From: Rhiannon Lloyd
Sent: 10 June 2025 09:41
To: Planning.Responses
Subject: FW: FG/64/25/HH - 4 Sea Lane
Attachments: Sea Lane_PL04B.pdf; Sea Lane_PL02D.pdf; Sea Lane_PL03D.pdf; Sea Lane_PL06A.pdf; Sea Lane_PL05B.pdf; Sea Lane_PL01D.pdf; Action Sheet.docx

FG/64/25/HH - 4 Sea Lane

FG/64/25/HH - 4 Sea Lane

Drawing: PL01C

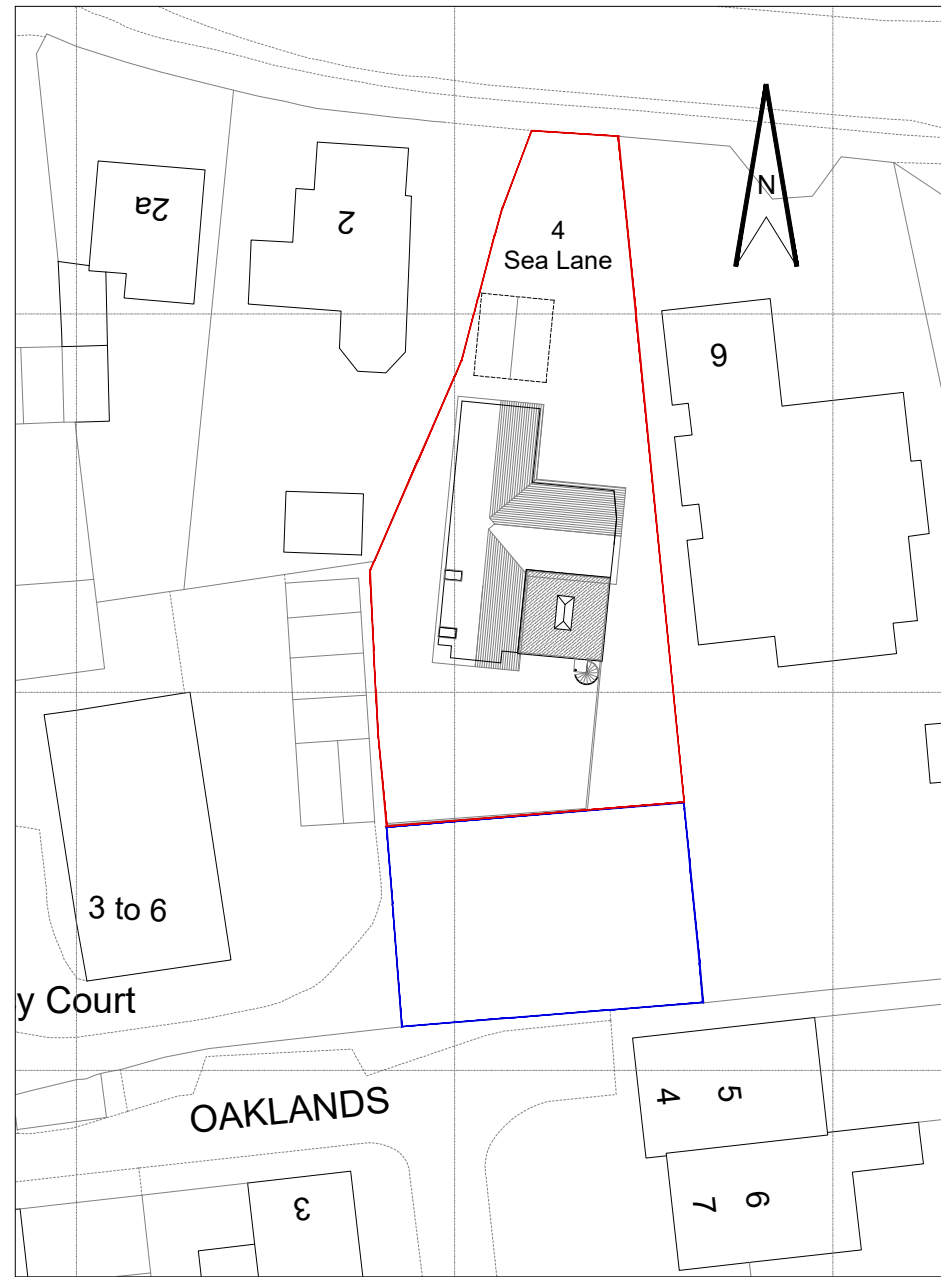
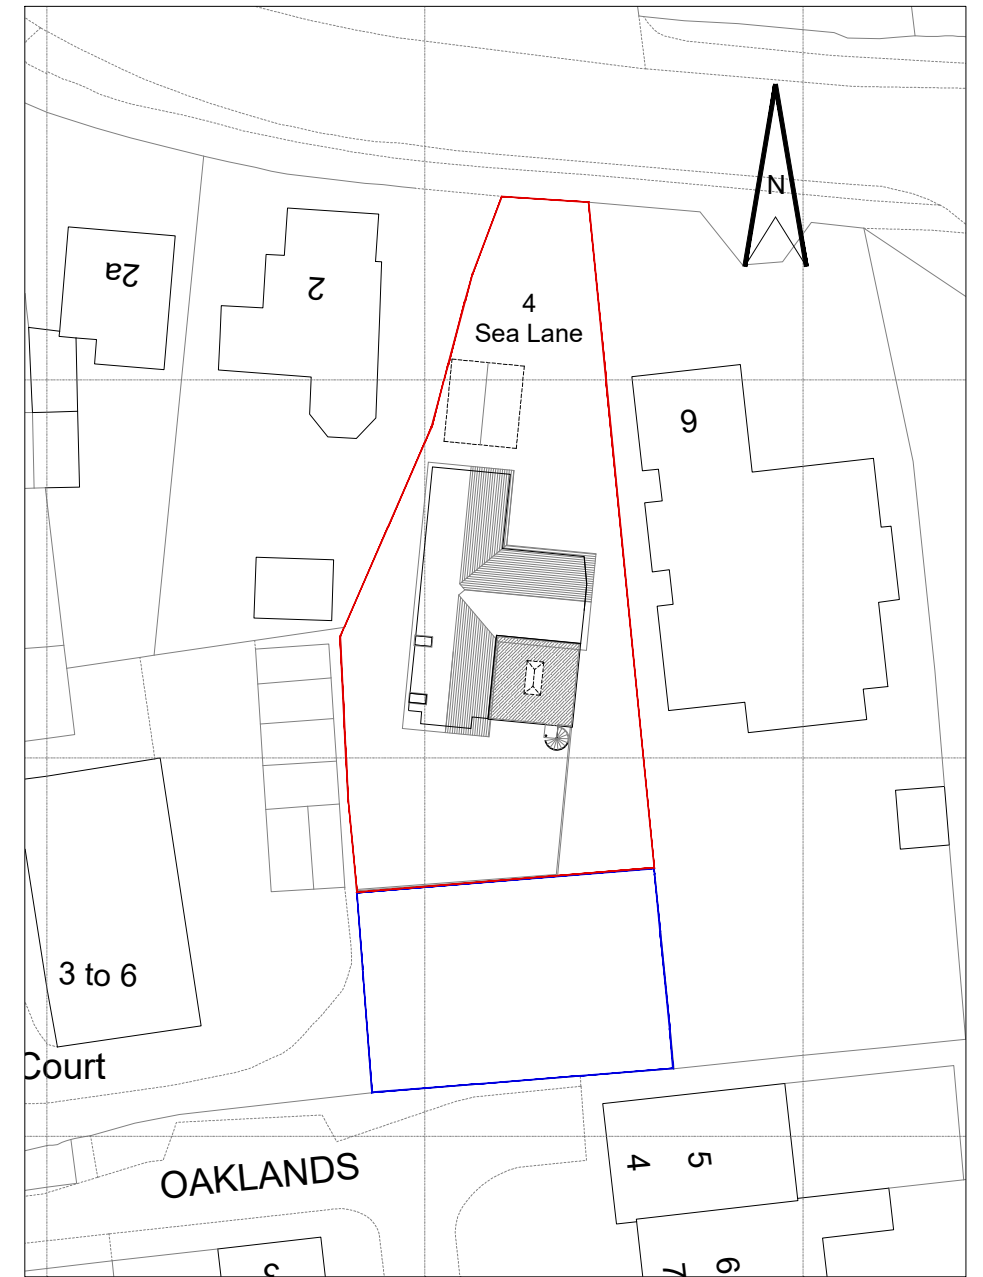
We also note that there is a bungalow to the rear of the site constructed recently under FG/203/21/PL, which is not included on the site/location plan. Please could you amend these plans to show this dwelling as the current plans are not reflective.

Please could the proposed gate also be shown on the site/location plan for clarity.

PL01D: Updated to show gates and approved bungalow
PL02D: Updated to remove sun-deck and stair
PL03D: Updated to remove sun-deck and stair
PL04B: Updated boundary distances showing approved bungalow
PL05B: Updated roof plan
PL06A: Showing gate reduced in height to 1.4m

25.313 Drawing: PL03C

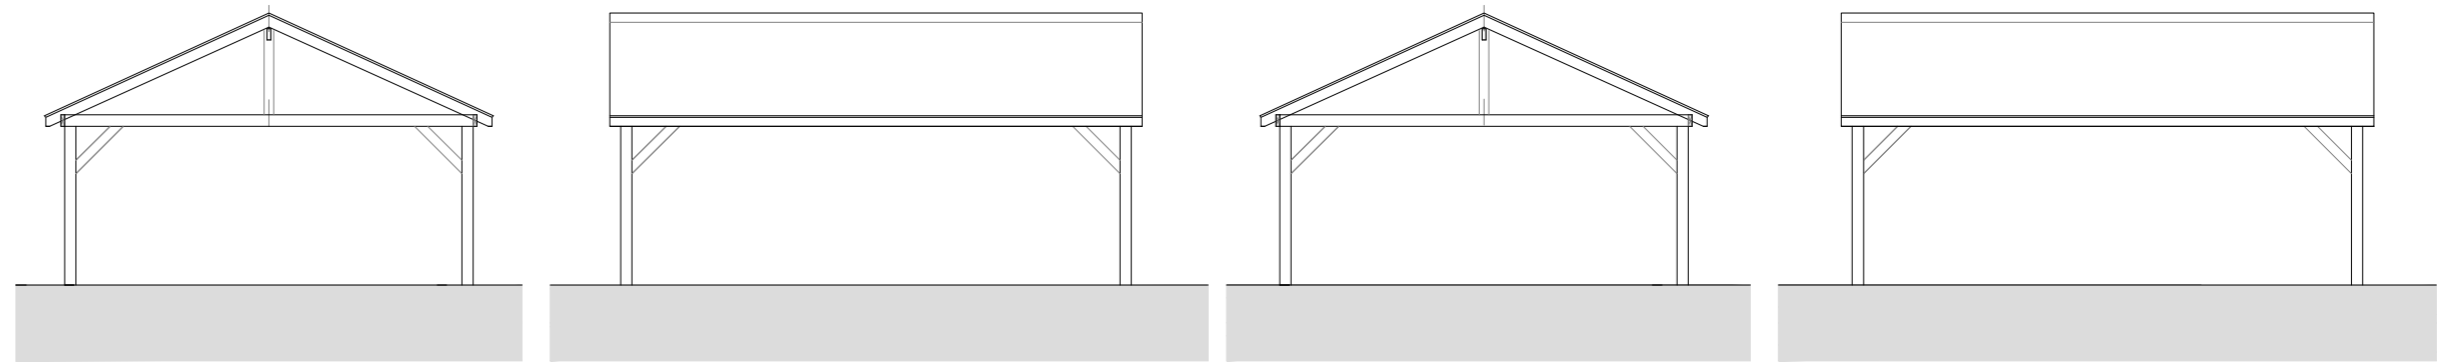
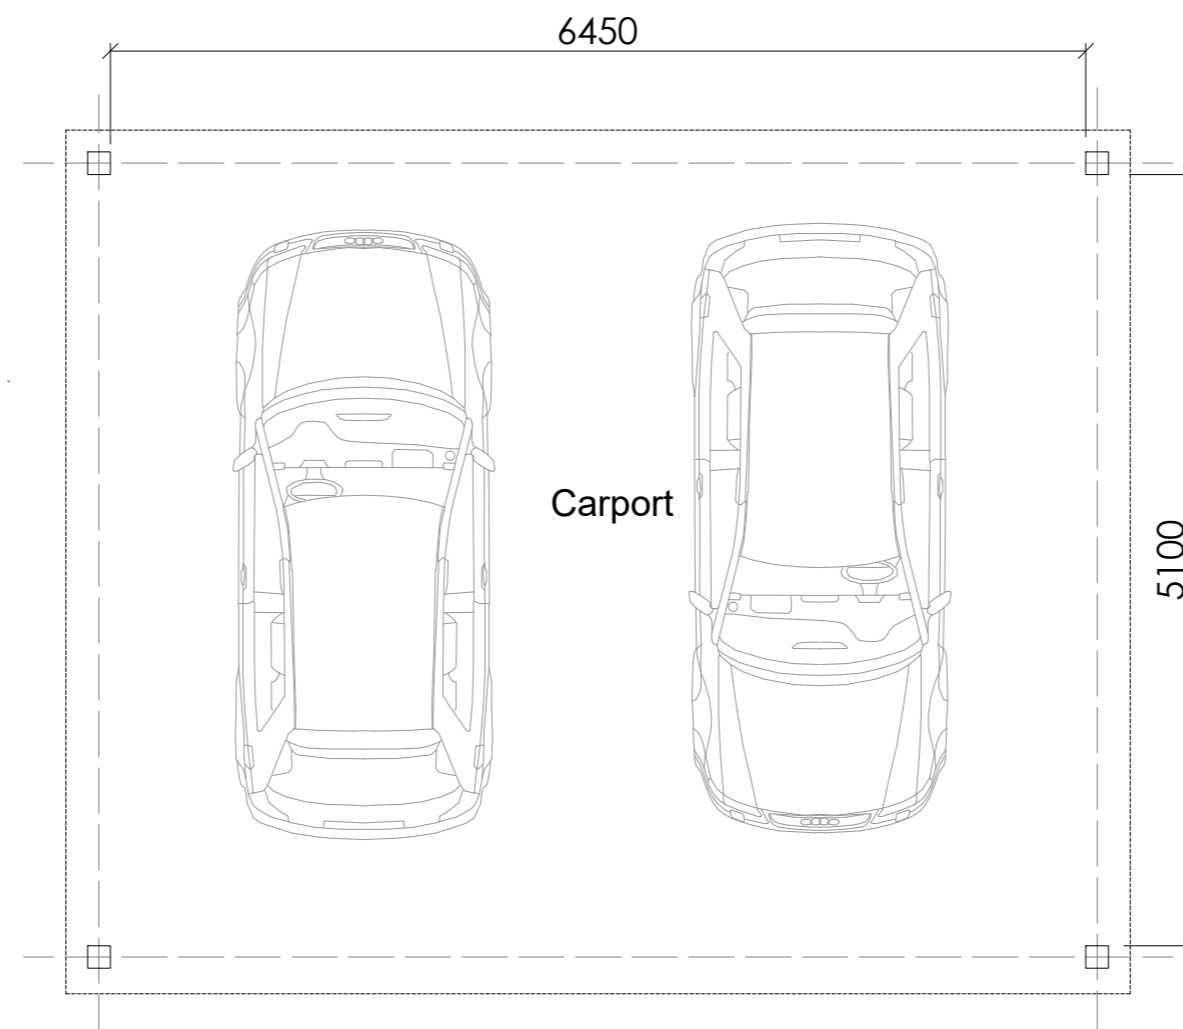
I have had a preliminary look at the proposal with my line manager and it is deemed that the sun deck is unacceptable, and we request that it is removed from the proposed plans in order to proceed.

Although there is screening in place, the sun deck will give rise to perceived overlooking of neighbours, nor are there any other examples of similar features in the vicinity thus it would be out of keeping with the established character.
